December 18, 2024

**Re: Abrazo Homes at Montage Unit 5 (Lots ?)
Erosion and Sediment Control Plan
Engineer's Stamp Date 12/9/24 (R16E006C_A)**

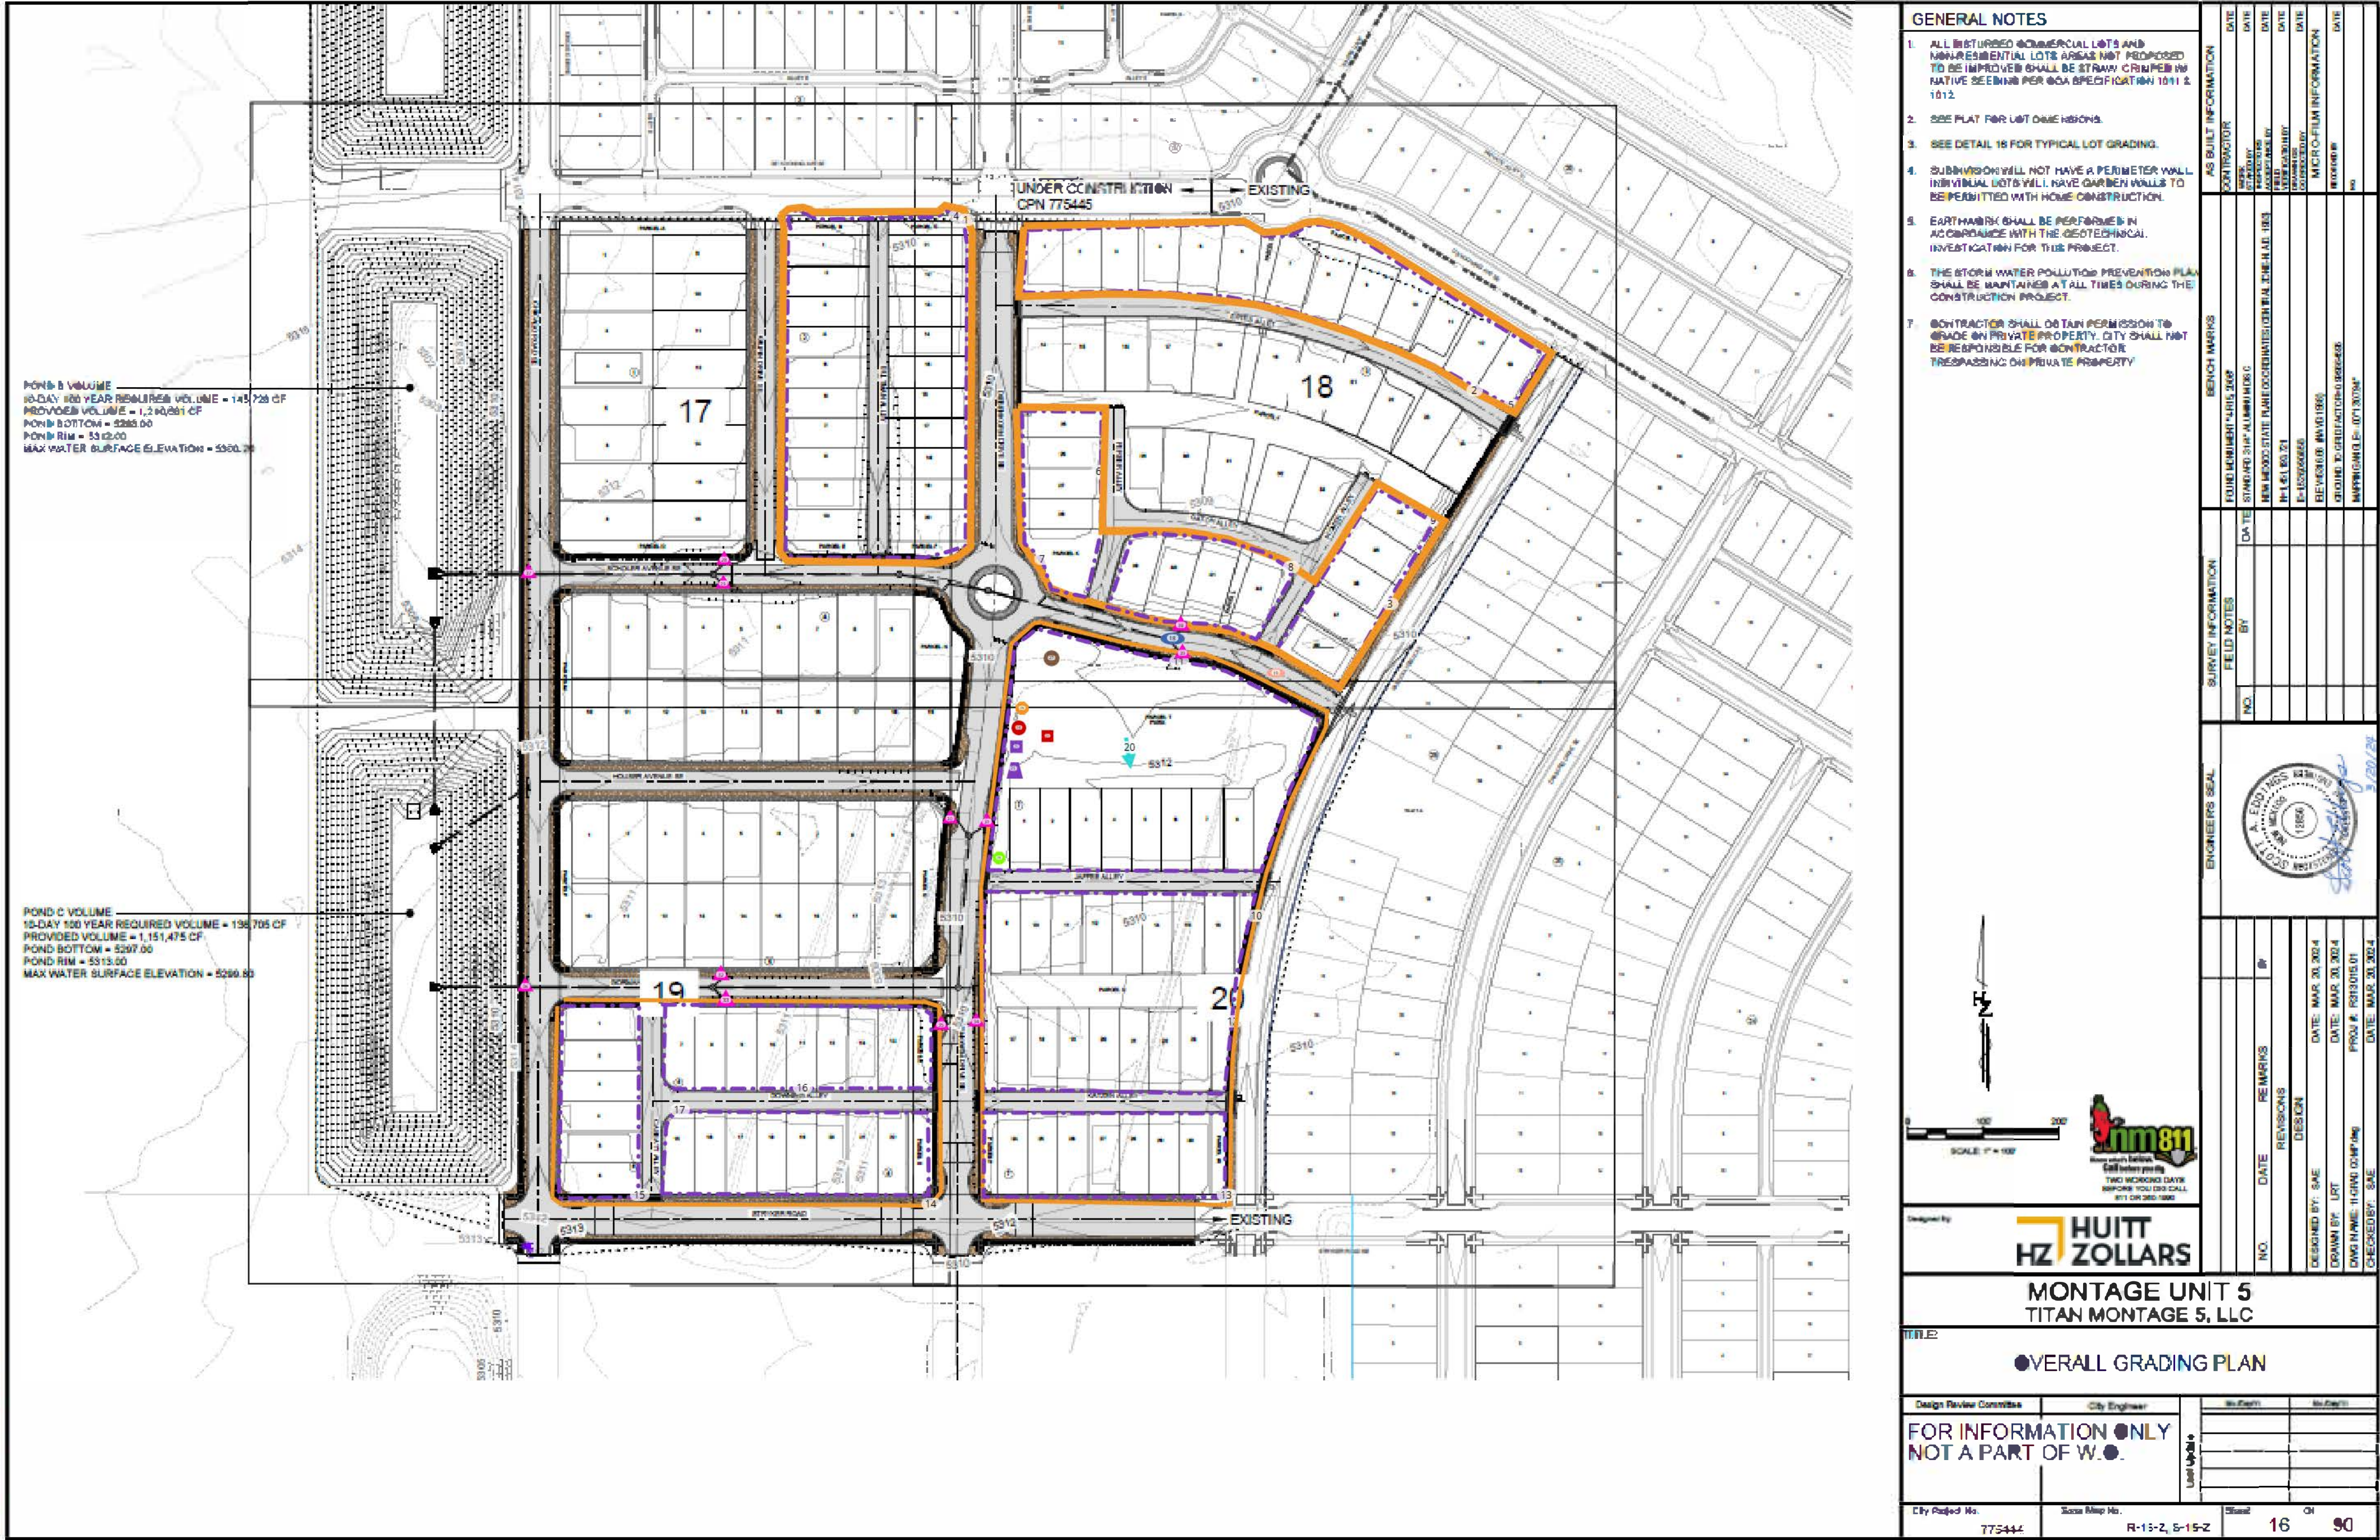
5. The text is blurred on sheet 4 of 9 of the ESC Plan. Lot and block numbers are not legible, and the contours are missing from that sheet. Existing and proposed contours must be shown on the ESC Plan as they are shown on Sheets 12-17 of the approved G&D Plan.

6. Cutback curbs are inappropriate where sidewalks are already constructed as part of the Work Order (WO). Use an alternative BMP, such as a silt fence, to keep sediment off the sidewalks that are constructed by the WO.

7. The title block, CPESC Stamp, Date, and Signature are missing from sheet 4 of 9. They are required. Update the engineer's stamp date on all sheets when a change is made to any sheet.
